KITTITAS COUNTY COMMUNITY DEVELOPMENT SERVICES

December 8, 2011

RE: H & C Trust Short Plat (SP-11-00011)

The Kittitas County Community Development Services Department has determined that the H & C Trust Short Plat (SP-11-00011) is a complete application and hereby grants *conditional preliminary approval* subject to the following conditions:

H&C TRUST SHORT PLAT A PORTION OF THE NORTHEAST 1/4 OF SECTION 33, TOWNSHIP 18 NORTH, RANGE 20 EAST, W.M., KITTITAS COUNTY, WASHINGTON

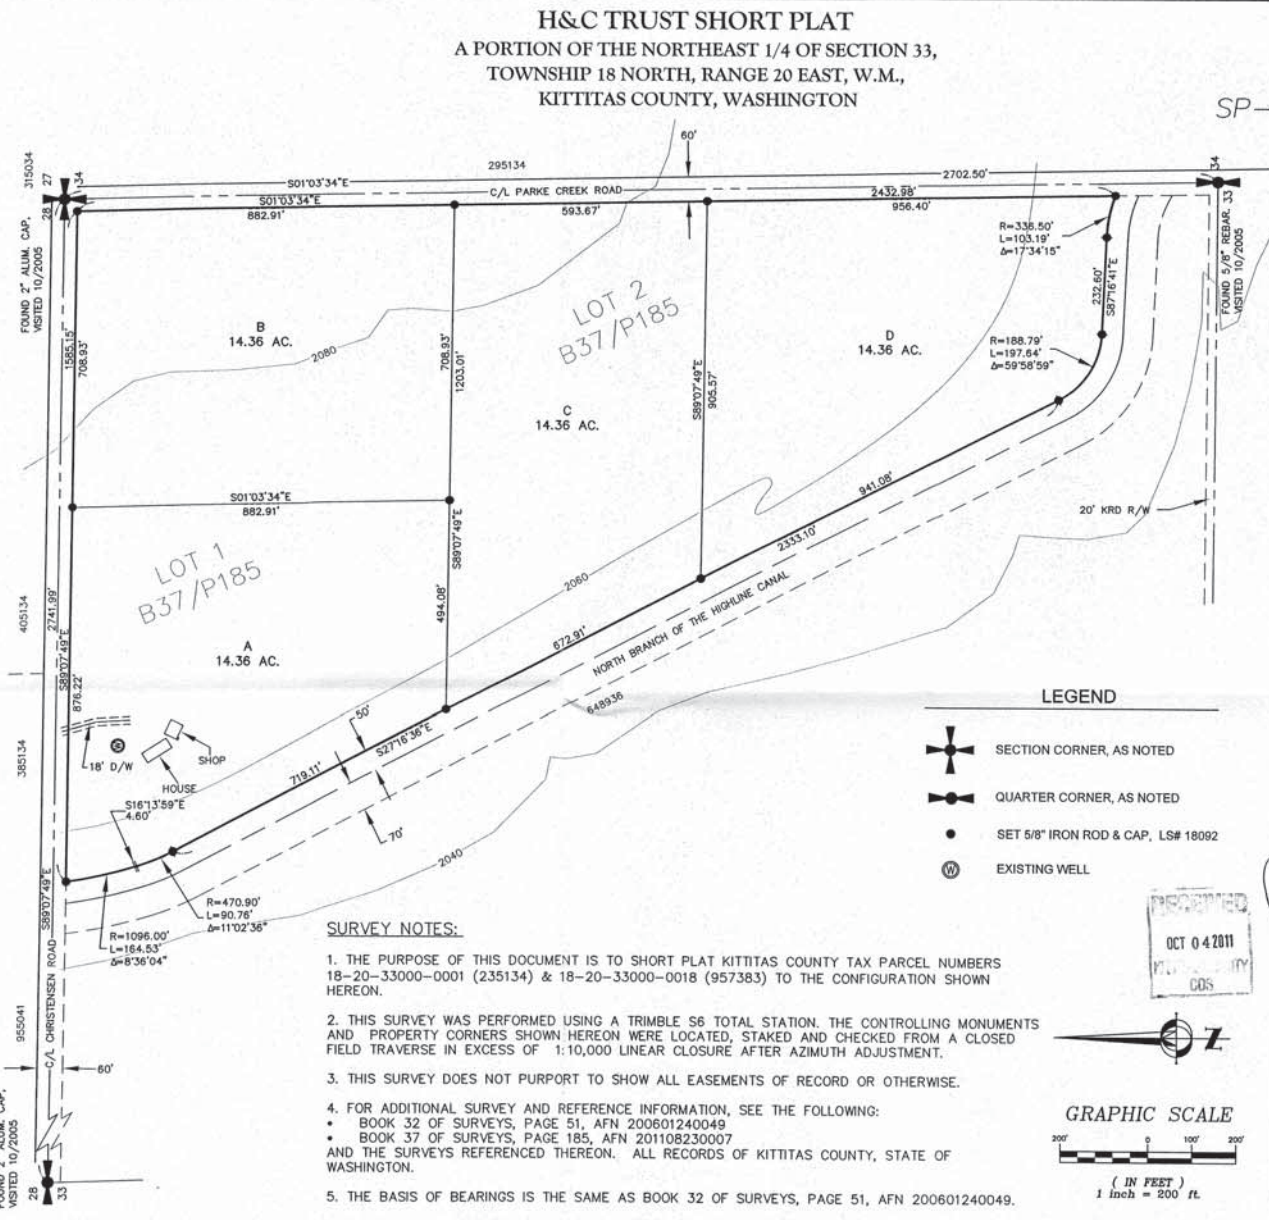
1. Both sheets of the final mylars shall reflect short plat number SP-11-00011 and an accurate legal description shall be shown on the face of the final plat.

4. The following plat notes shall be recorded on the final mylar drawings:
 - All development must comply with International Fire Code.
 - This short plat has exhausted the use of the one time split provision allowed per Kittitas County Code. No further one time splits are allowed for the subject parcels and subsequent parcels created via this short plat.

6. A statement regarding the contemplated sewage disposal, water supply, and drainage improvements for the proposed subdivision shall be reflected on the final mylars.
